CITY OF ALBUQUERQUE

March 7, 2023

**RE: Lot 6 – 3151 Bridge St. SW
Grading and Drainage Plan
Engineer's Stamp Date: 02/28/23
Hydrology File: L11D067D**

LOT 6 PLOT PLAN

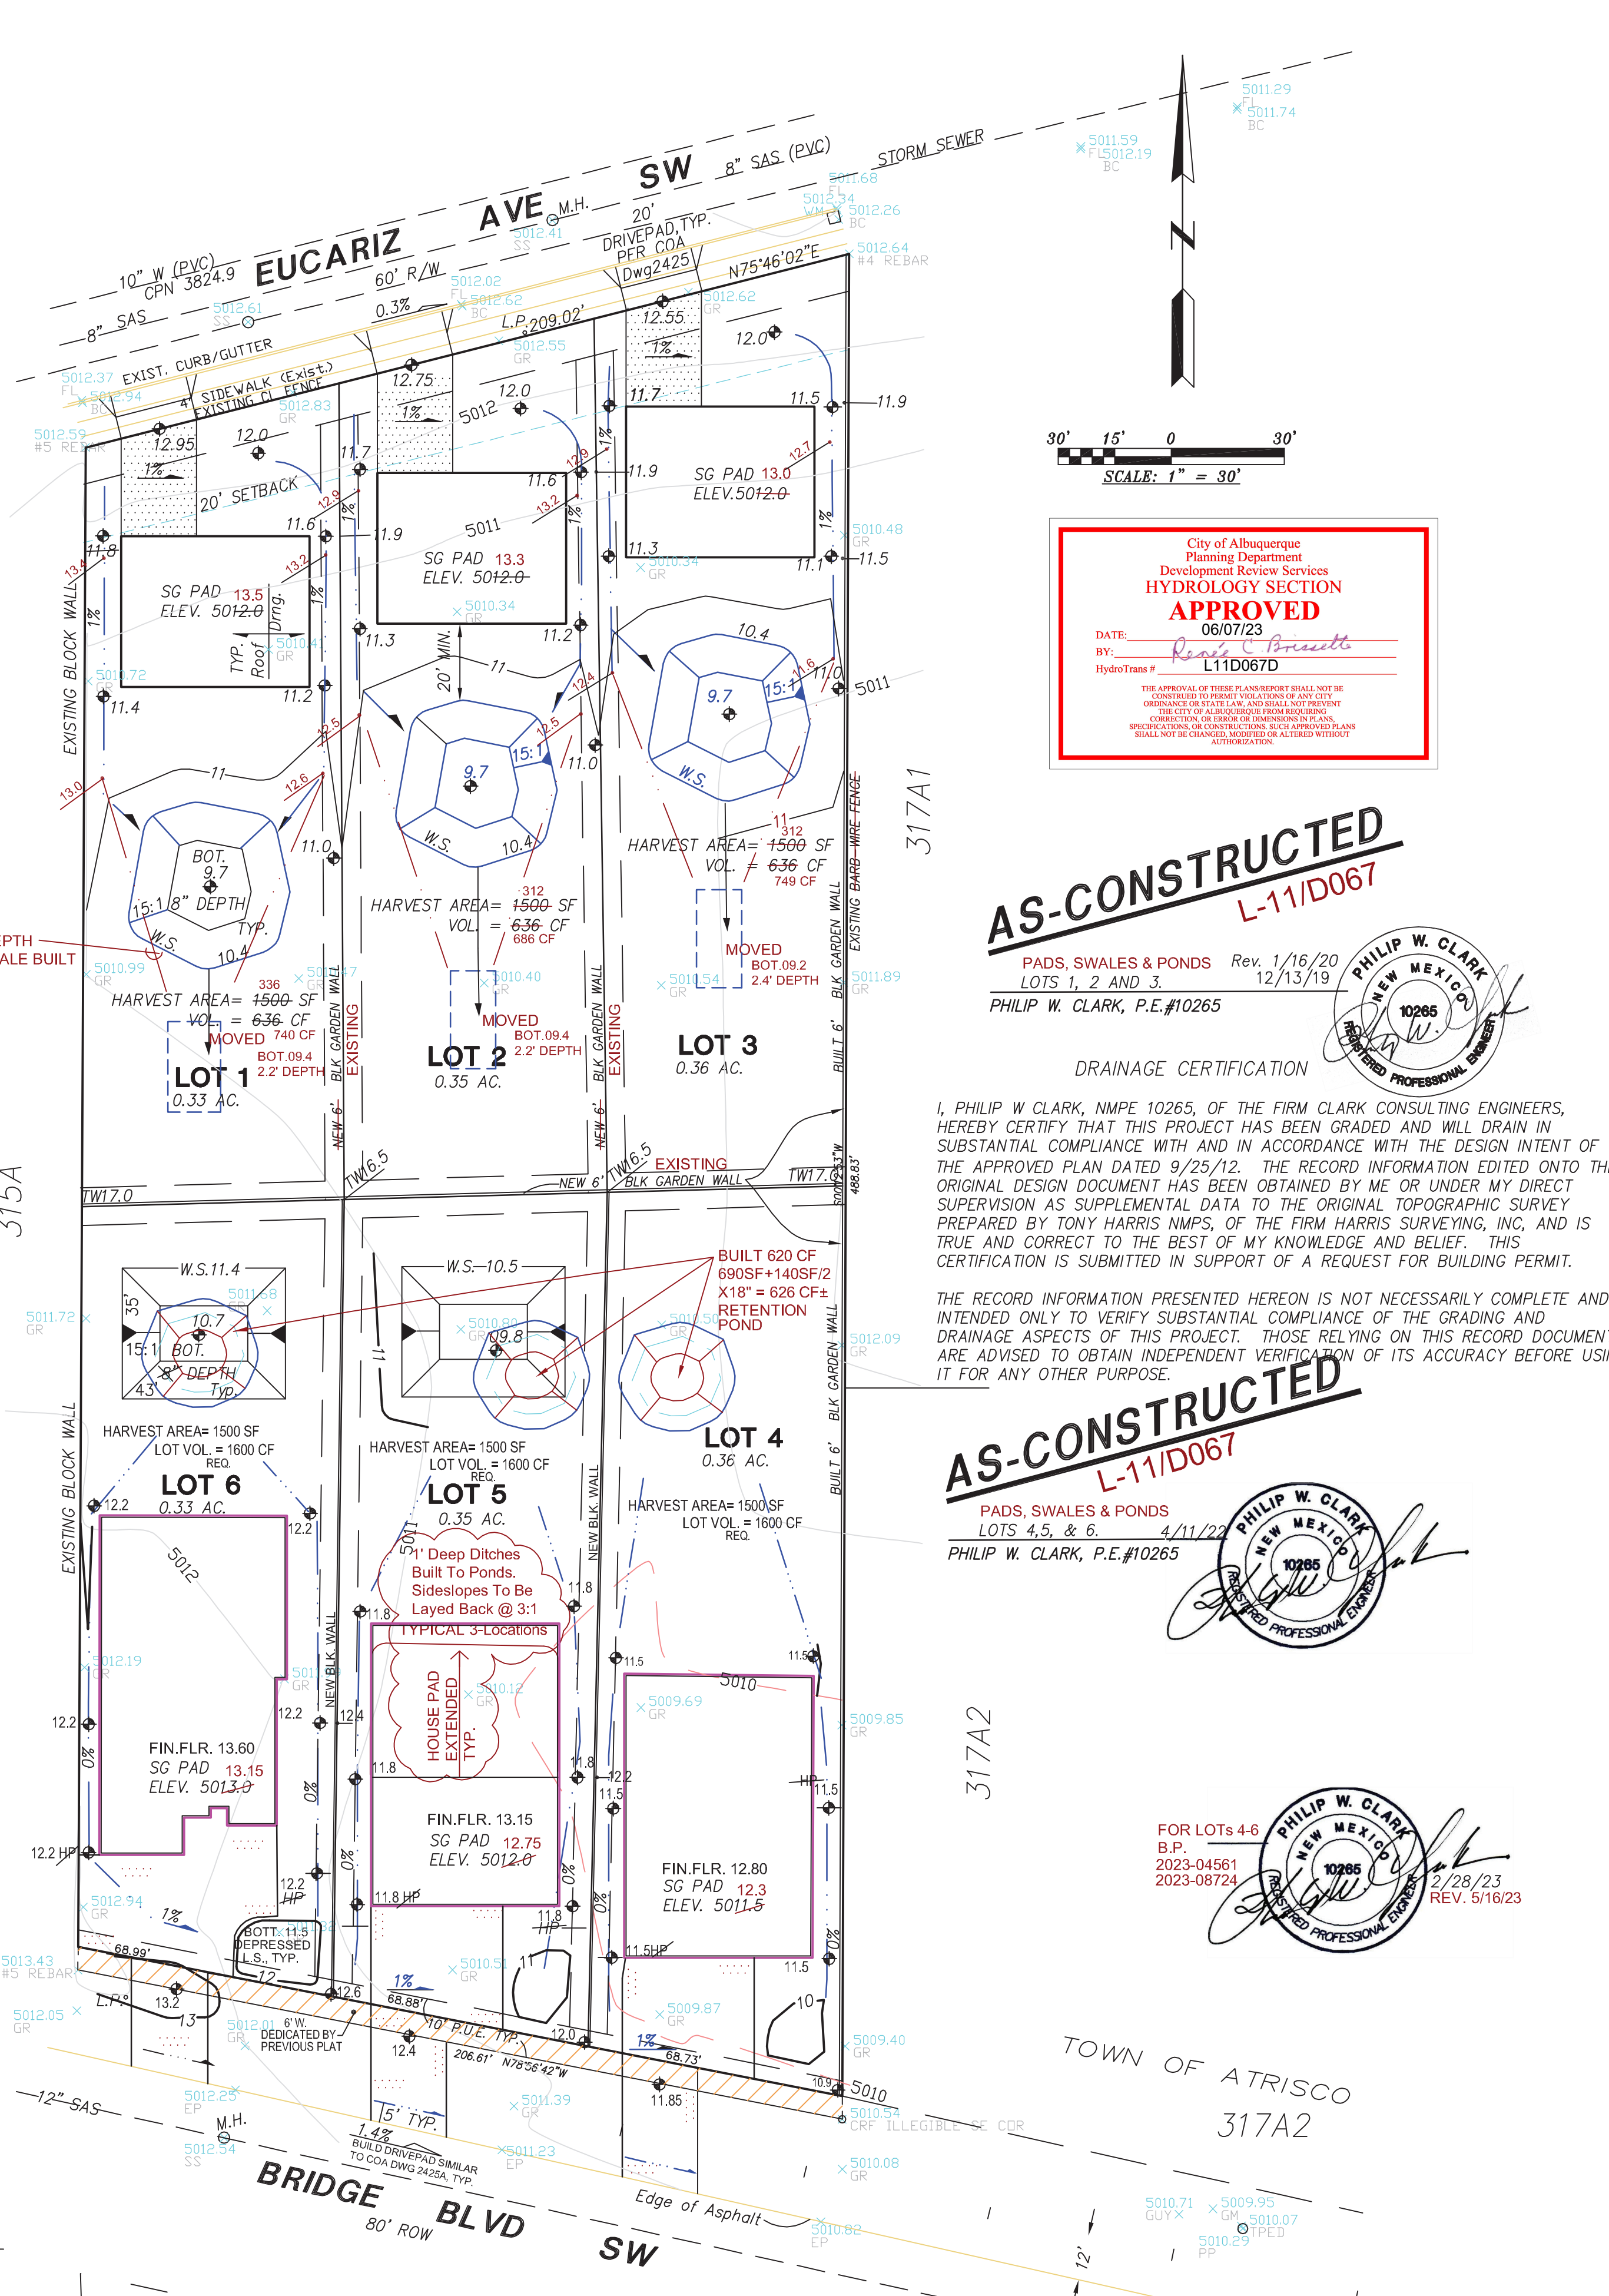
1. This entire subdivision has been modified from the approved Lots 1-3 Pad Certification approval given on January 21, 2020 of which as-built certification & Permanent Certificate of Occupancy approval by Hydrology was never issued for each of these Lots. After Lots 4-6 Pad Certification approval was given on April 15, 2022, there was major grading done on these lots which can be seen on the aerial below. Therefore, Hydrology request a new as-built survey for Lots 4, 5, & 6 be done and shown on the submittals for these Lots for Building Permit. Also, please just show each lot separately with current drainage calculations that adhere to Chapter 6 of the current DPM. Remember for Lot 6, the retention pond required will be the proposed house and driveway impervious area for the 100 year – 10 day volume as outlined in Article 6-5.

2. Since this site is in the Valley region, please follow Article 6-5 Valley Drainage Criteria of the DPM. The following conditions must be applied to the site:
 - a. The maximum percent impervious of the lot and the contributing area may not be greater than 45%.
 - b. Pad elevation shall be a minimum of one (1) foot above the 100 year 10-day stormwater surface elevation.
 - c. The flow between the front yard and back yard cannot be obstructed. The stormwater must be allowed to equalize to the same level between the front yard and back yard.
 - d. A permanent perimeter wall or barrier around the development is required to contain the 100-year 24-hour storm developed runoff.
